R/285/19/HH - 17 Glenville Road Rustington (single storey rear extension)

With regard to the above project my client (in the spirit of being neighbourly) has instructed me to reduce the bulk of the extension located within the outrigger as indicated on the revised drawings 1934-03D and 1934-04D enclosed.

Scale 1:50 @ A1 Date AUGUST 2019 Drawing Number 1934-03D

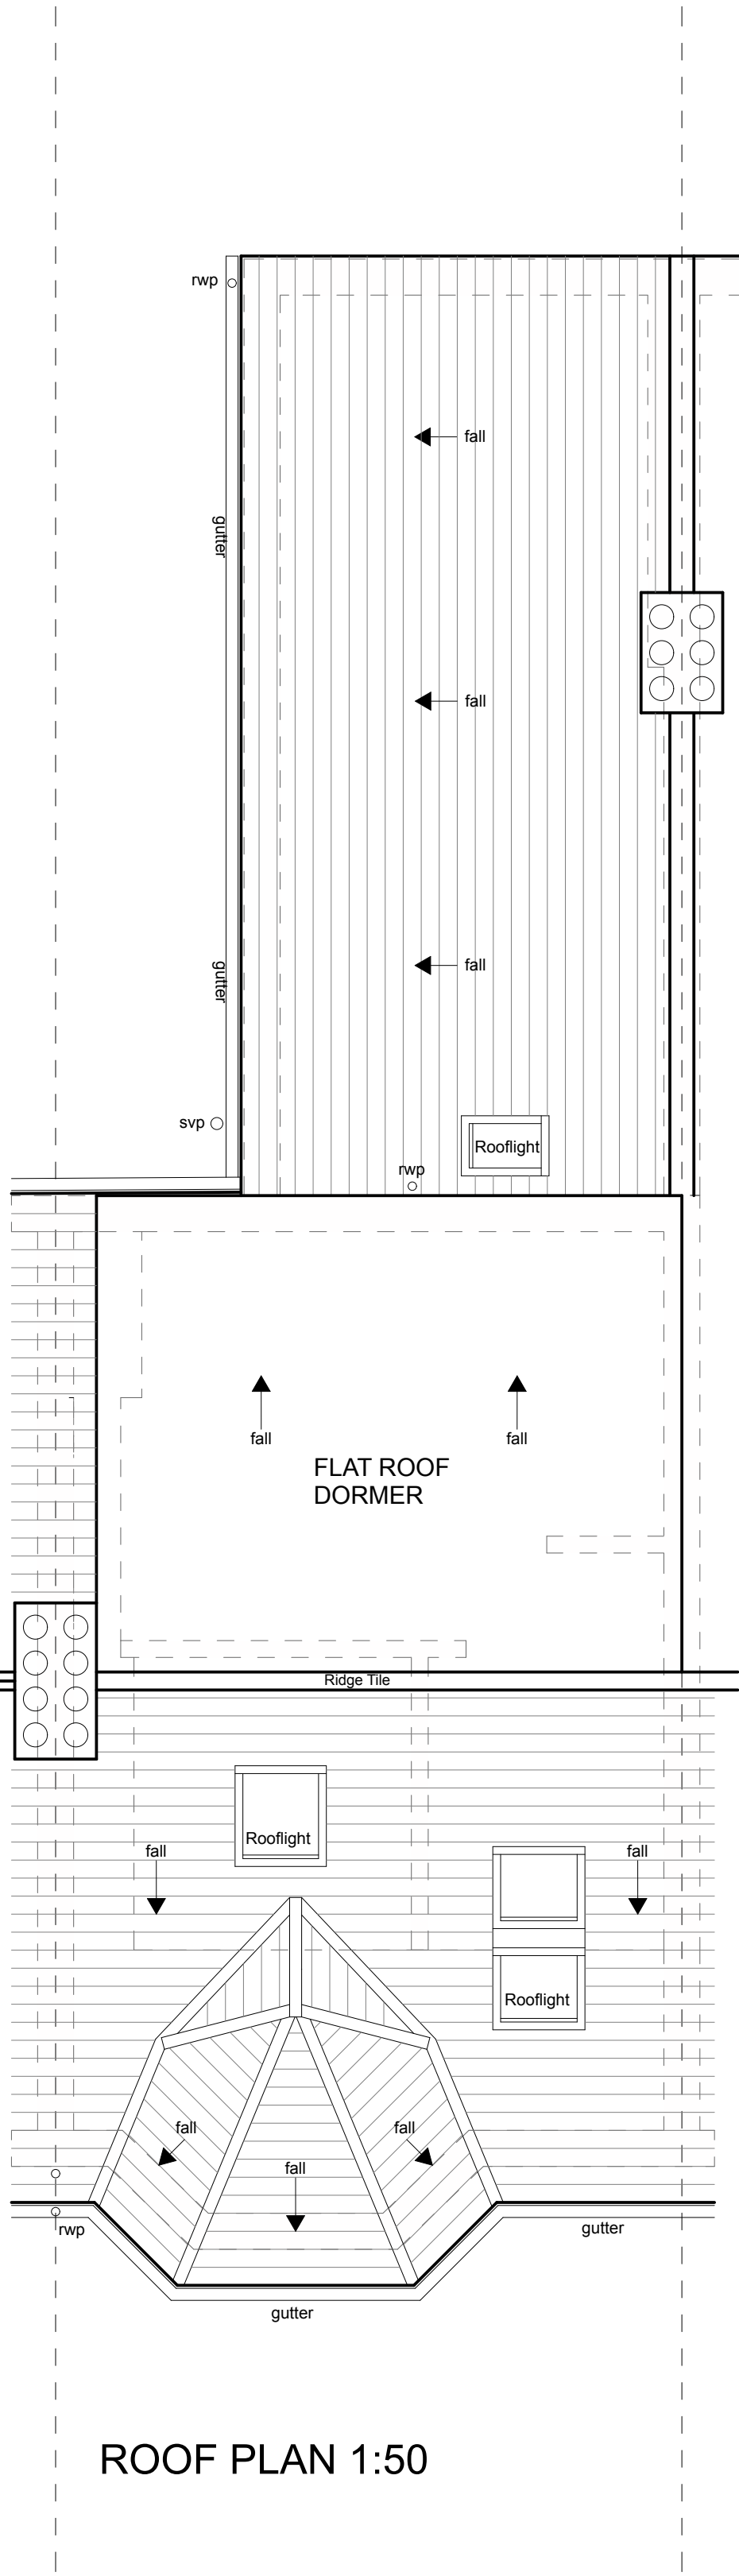
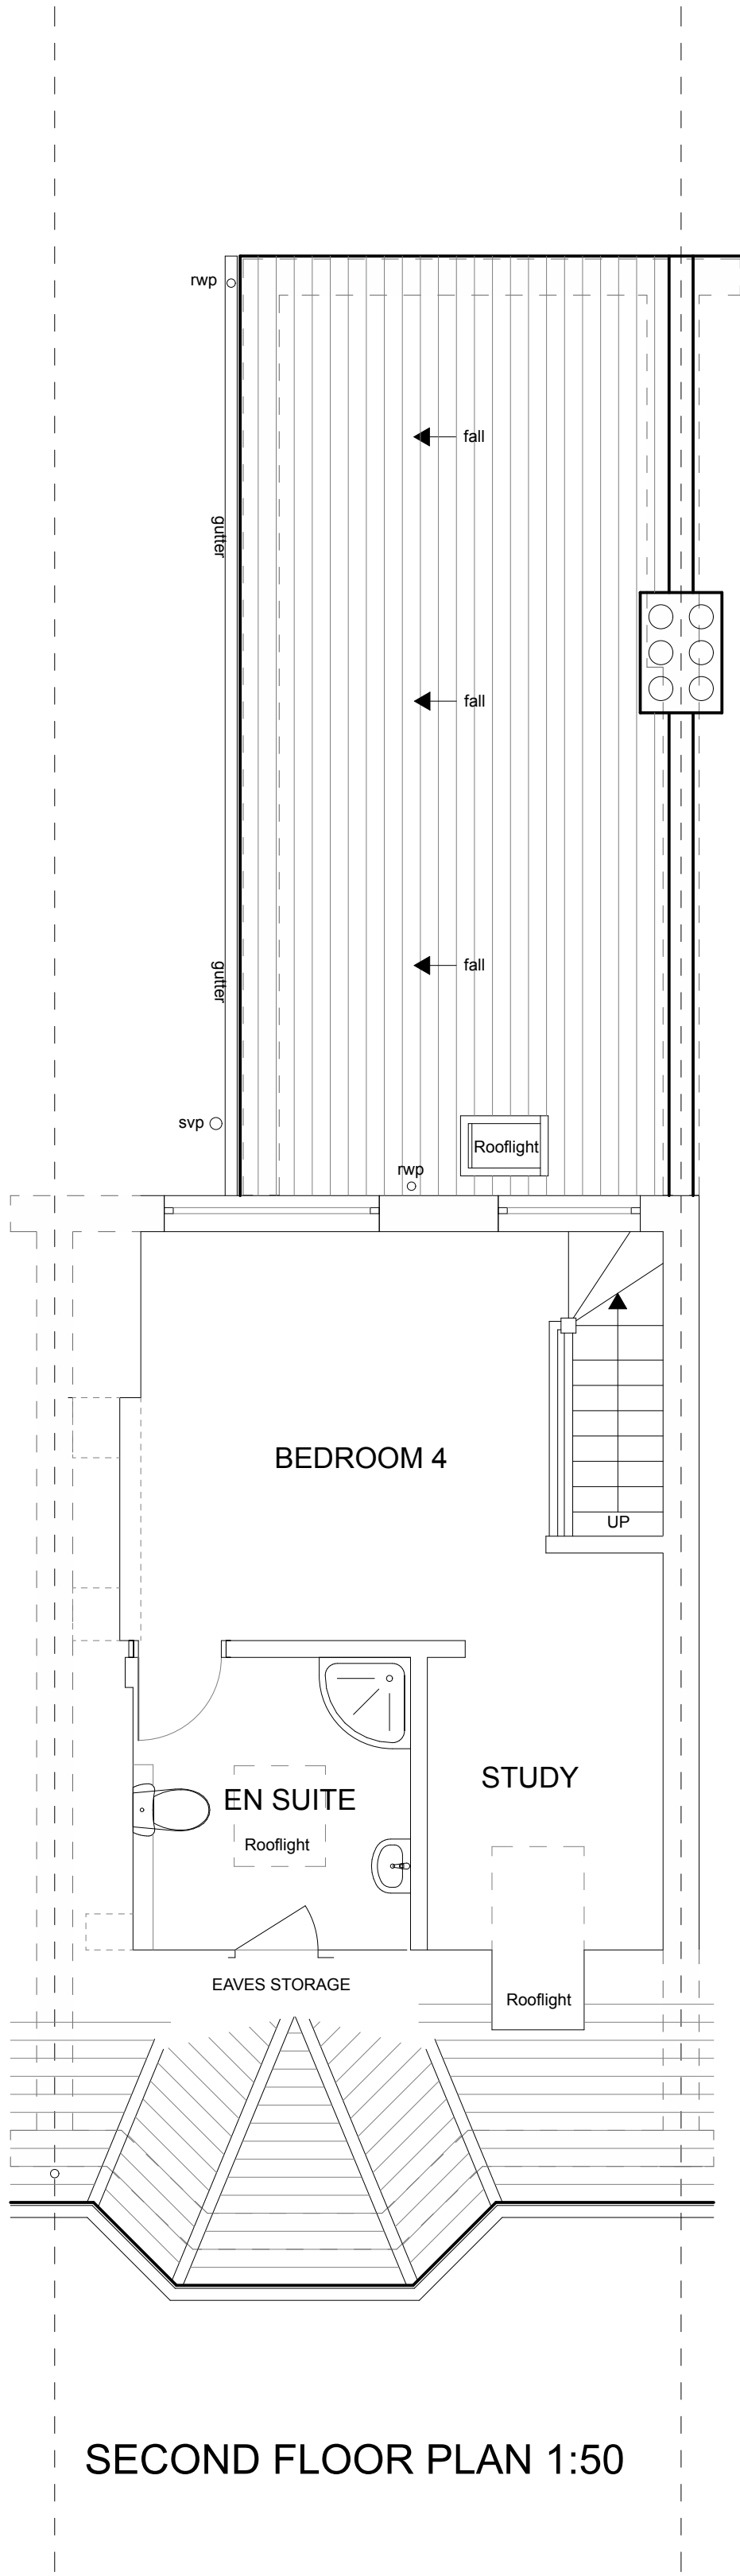
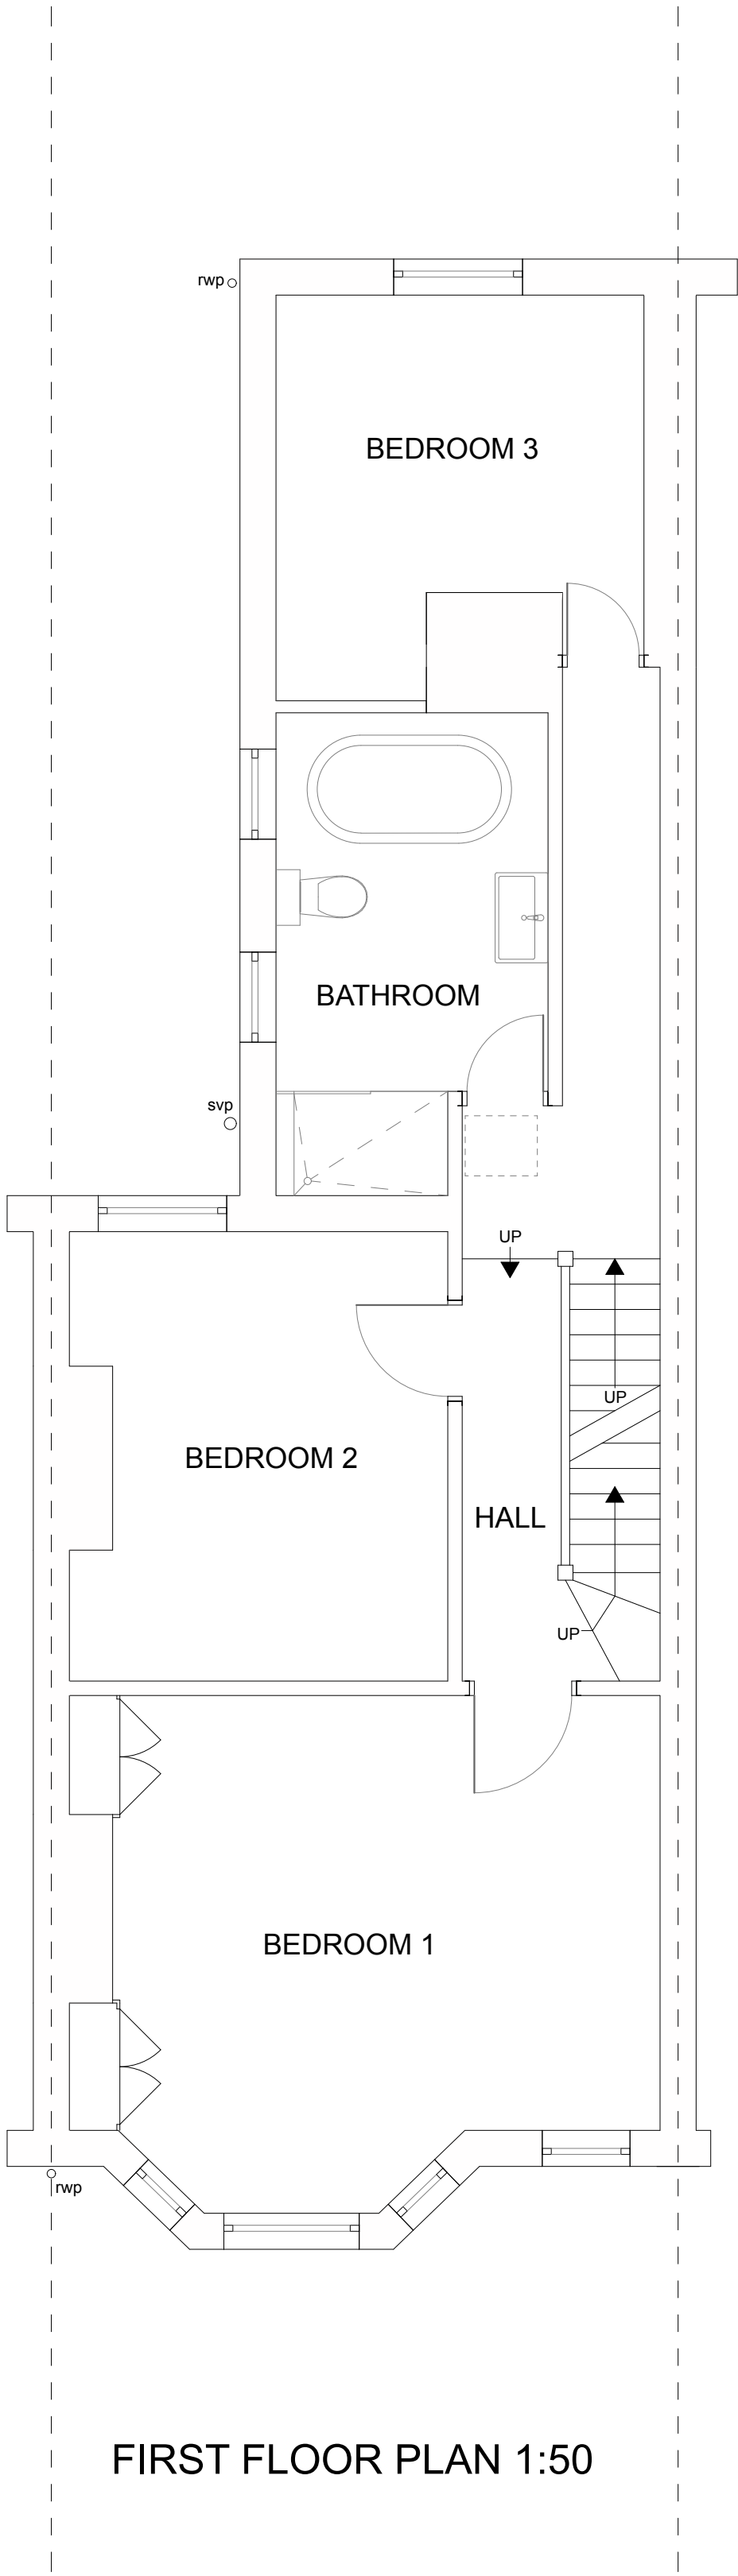
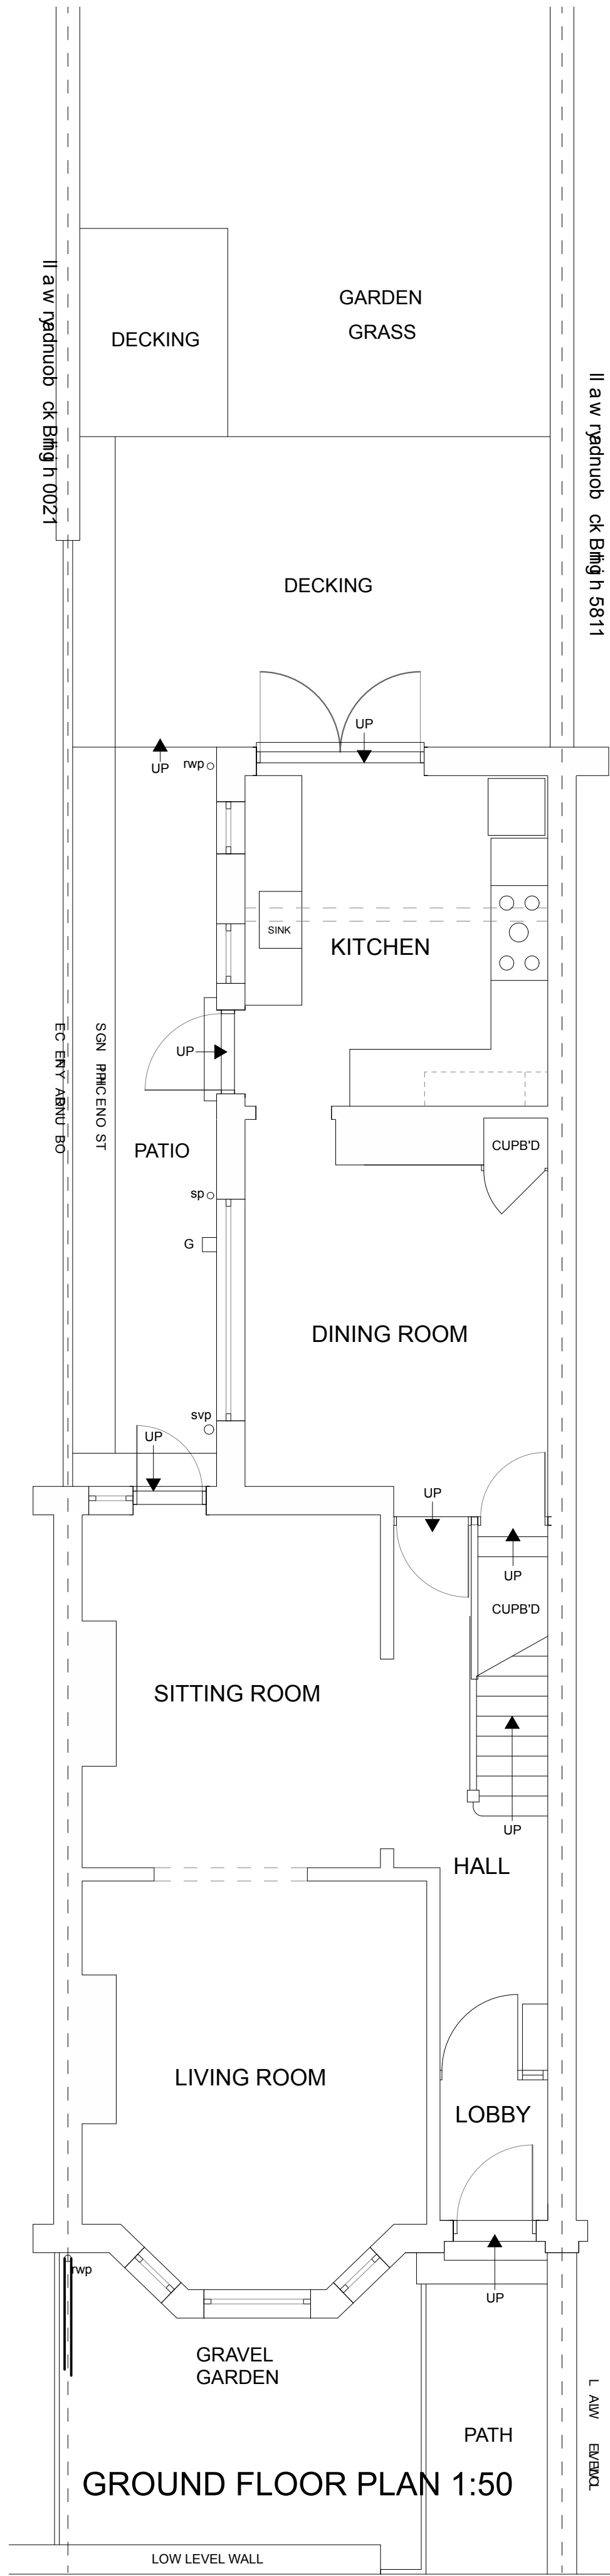
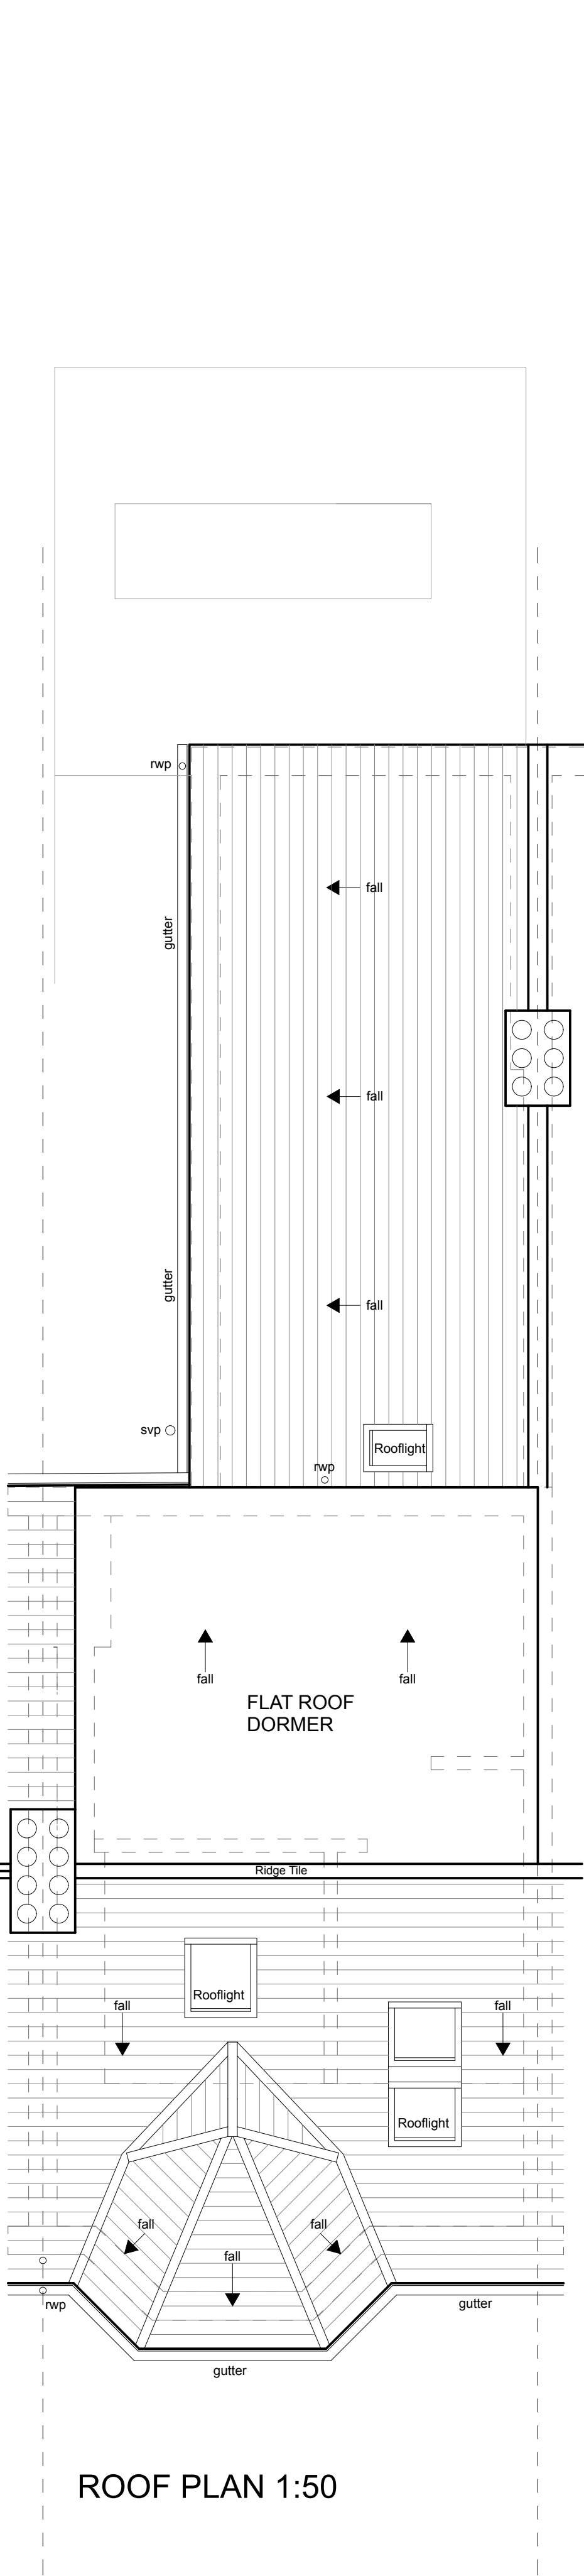
Whilst they have no objections to the main part it is the return down the side that was concerning them.

Light is a major issue as these North rooms are dark and their large side window would effectively be looking at a solid wall. I fully appreciated their concerns - I would have had the same, roles reversed.

I like our neighbours and do not wish to upset the apple cart for a few extra feet. Is it possible to amend the plans so that the extension purely covers the back of the house and not down the side return?

The side door in the kitchen (leading out to the Courtyard) will remain blocked up as on the plans but both of the single windows will be re instated. Finally, could we have a fully glazed window/ door looking into/ down the Courtyard from the new extension.

Happy new year and thank you for your e mail.
I have now amended the drawing which you may wish to further discuss with your neighbour.
I've adjusted the rooflight position to suit the revised shape of the room.
I would be tempted to introduce a window to the courtyard elevation within the existing door location.
